From: Ellie Myers <ellie.myers@co.kittitas.wa.us>
Sent: Thursday, August 14, 2025 7:15 AM
To: jill johnson <jmjohnson60@msn.com>
Cc: Dan Suggs <dan.suggs@co.kittitas.wa.us>; Jamey Ayling <jamey.ayling@co.kittitas.wa.us>
Subject: RE: I am sharing '525135_JOHNSON' with you

Yes, the site plan I sent is the one from Mark Nelson that you sent me yesterday, and it shows setbacks that do not meet shoreline requirements. I wanted to point out that both the house and the septic tanks are shown as being closer than 115 feet from the Ordinary High-Water Mark (OHWM). Development is not allowed within 115 feet of the OHWM, including the installation of septic systems, unless buffer averaging is approved.

1. A revised site plan that clearly shows both the house and the septic tanks located more than 115 feet from the OHWM. Also, I need confirmation that this updated plan has been submitted to Public Health, so everyone is on the same page.

OSS SITE PLAN

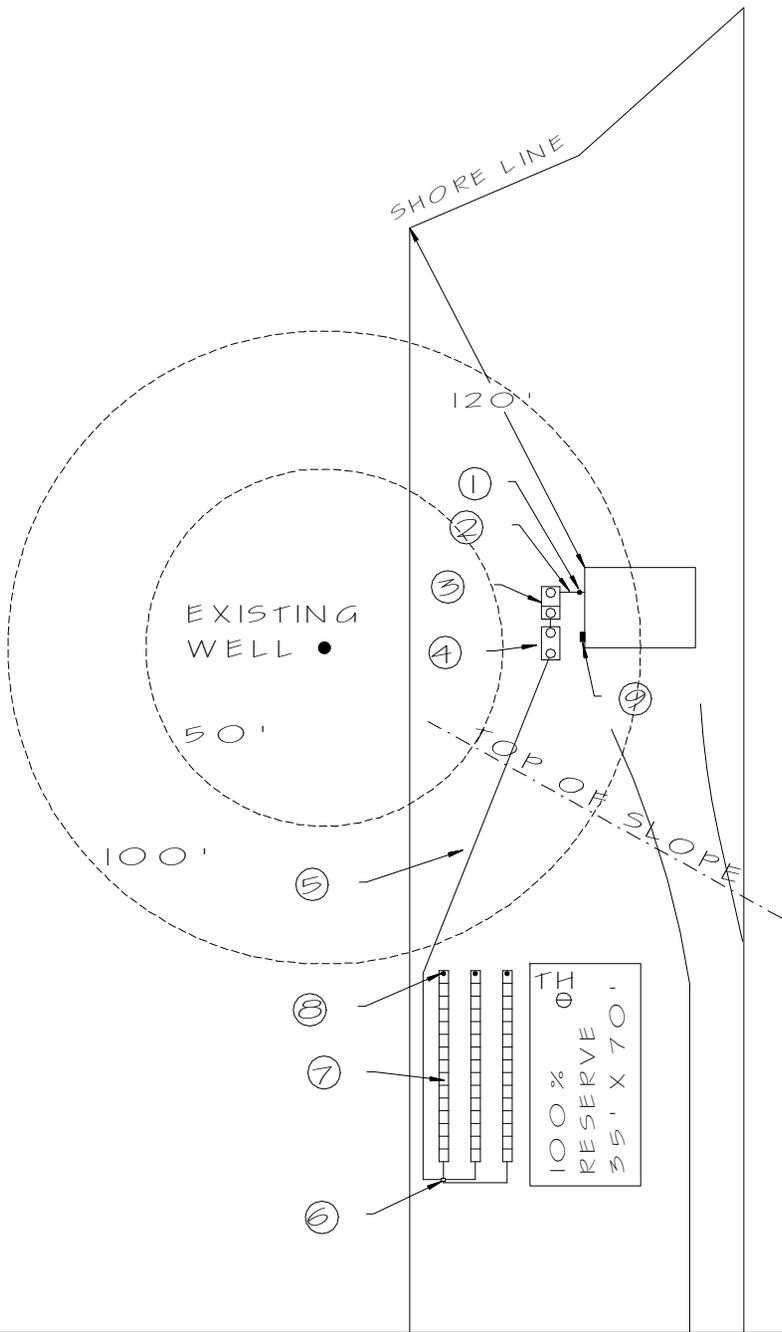
2. Request to use Common Line Shoreline Buffer averaging and submit a Management and Mitigation Plan prepared by a qualified professional that includes enhancement measures, to allow building within 115 feet of the OHWM.

Hi Ellie. Thank you for checking back with me. We have a better understanding of what you are looking for. Mark is redoing the design to be moved back. Later when I build if I ever get to that i will hire someone to Survey the parcel. For now this is all I can do for the year:) appreciate you.
